From: Richard Andrew [REDACTED]
Sent: 07 July 2022 17:06
To: Andrew Wood <Andrew.Wood@arun.gov.uk>
Subject: K22/22 - Three Stables & a barn - Land East of Kingston House Kingston Lane Kingston BN16 1RP

THE NEW STABLES, KINGSTON, EAST PRESTON, WEST SUSSEX, BN16 1RP	
Client	Description
PROPOSED PLANS, ELEVATIONS & SECTIONS FOR STABLES & BARN

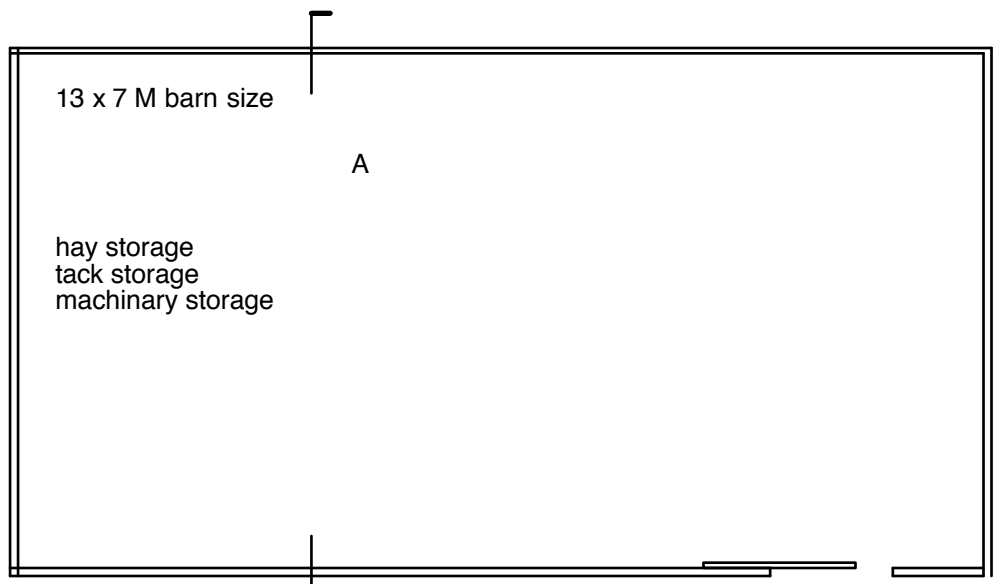
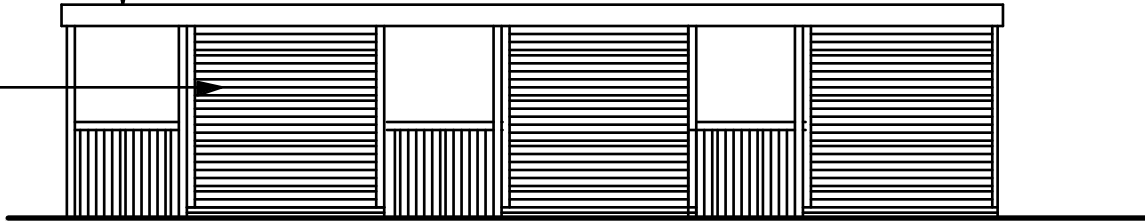
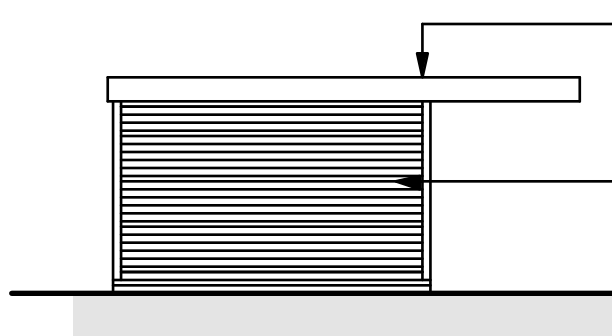
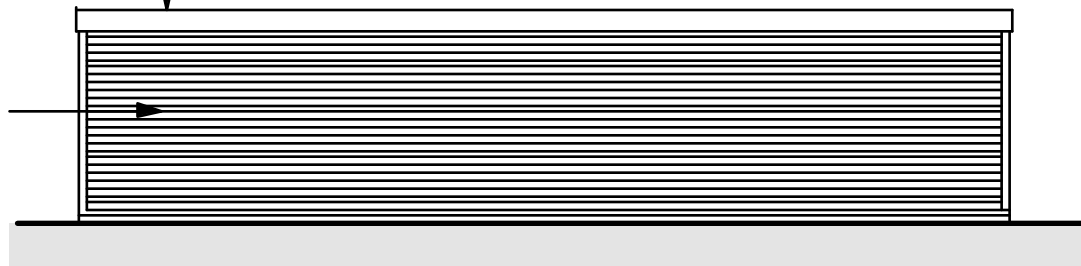
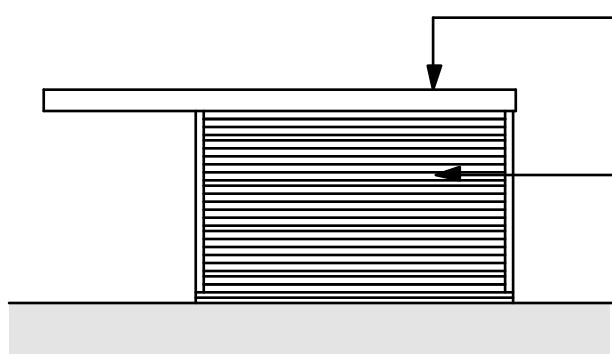
1. Presently the land is grazing, yet no justification is given for the construction of a large building including significant concrete hardstanding of 20m x 25m. 3 x larger than consented on the same site under K/24/18/PL

2. Materials proposed to the barn, namely green clad walls and roof, are inconsistent with the rural location.
3. Whilst the use is defined as "stables" the actual use applied for is for B8 storage and warehouse of 138 sq m; this is inconsistent with an agricultural use.
